Post Point CHN 215
Hertfordshire County Council
County Hall, Pegs Lane
HERTFORD SG13 8DN

Date 07 January 2020

RE: 6/2019/3112/COND – Street Record, Chequers Field, Welwyn Garden City

Thank you for consulting us on the above application for the submission of details pursuant to condition 7 (surface water drainage scheme) on planning permission 6/2018/1519/MAJ, at Street Record, Chequers Field, Welwyn Garden City, AL7 4SX.

**Soakaway no.**

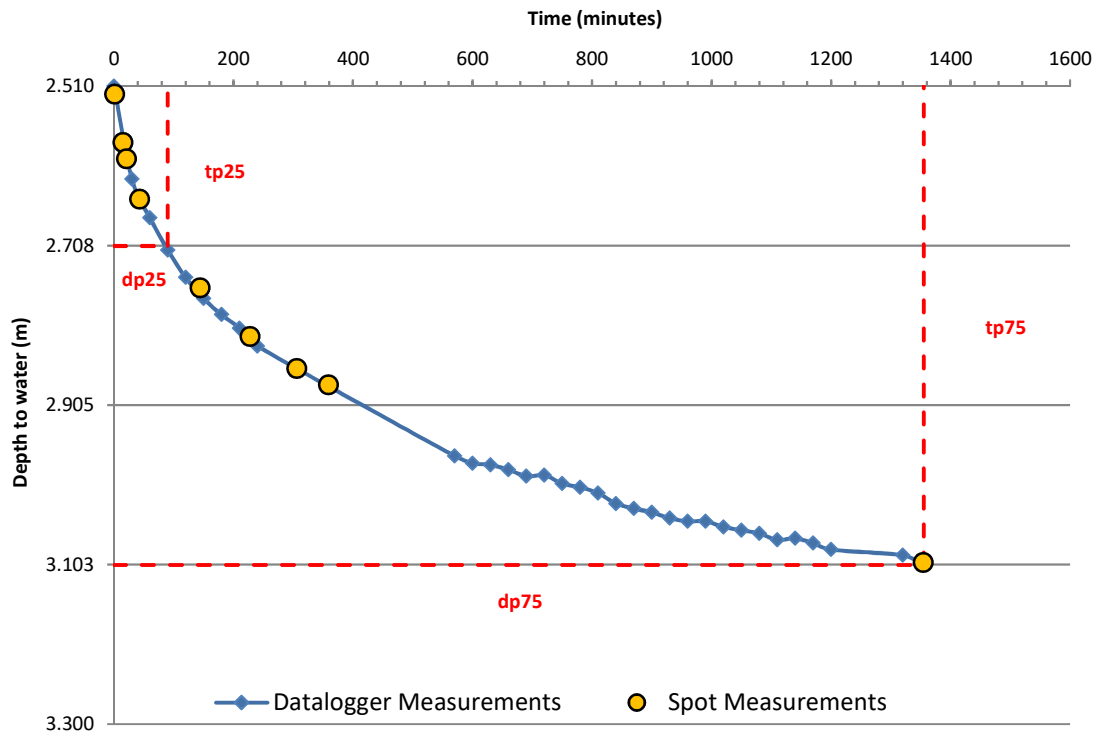
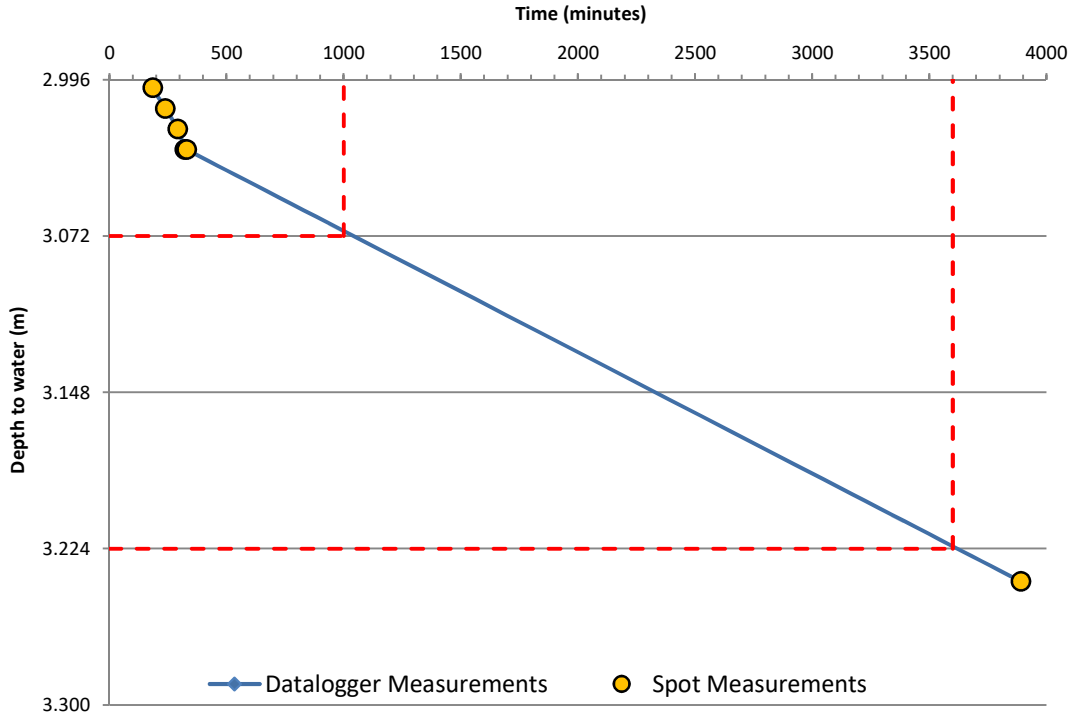
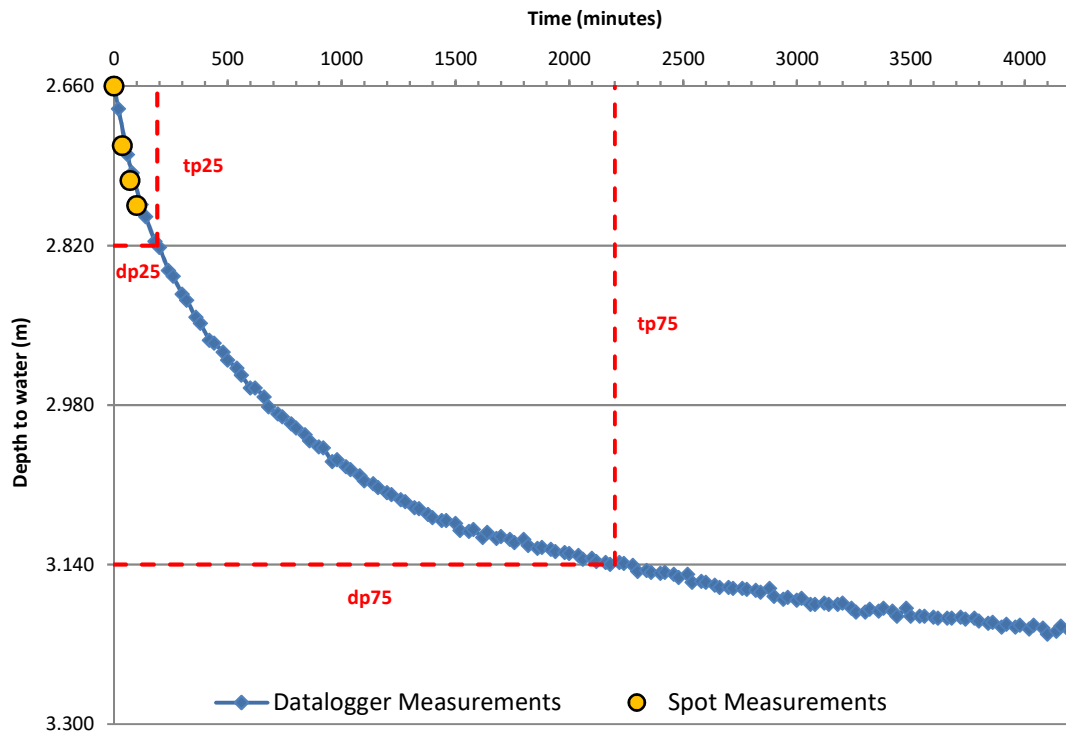
We note that soakaway 3 is designed with its depth being 3.9m, therefore we would consider this to be more akin to a deep bore soakaway. In addition, the development site lies within Source Protection Zone 3 and, as mentioned above, we understand that there is a risk of contamination at this location. We acknowledge the addition of a proposed 1800mm diameter silt trap to provide additional storage and address potential contamination; however we would strongly recommend that the Environment Agency (EA) should be consulted on the suitability of a soakaway at this depth for location. We are not aware if the EA has been consulted following our previous response.

As the LLFA, we would consider soakaway 3 to be a deep bore soakaway. The development site lies within Source Protection Zone 3. As mentioned above, there is a risk of contamination on site. Therefore, we would strongly advise the LPA that the

Environment Agency should be consulted on suitability of a deep bore soakaway at this location.
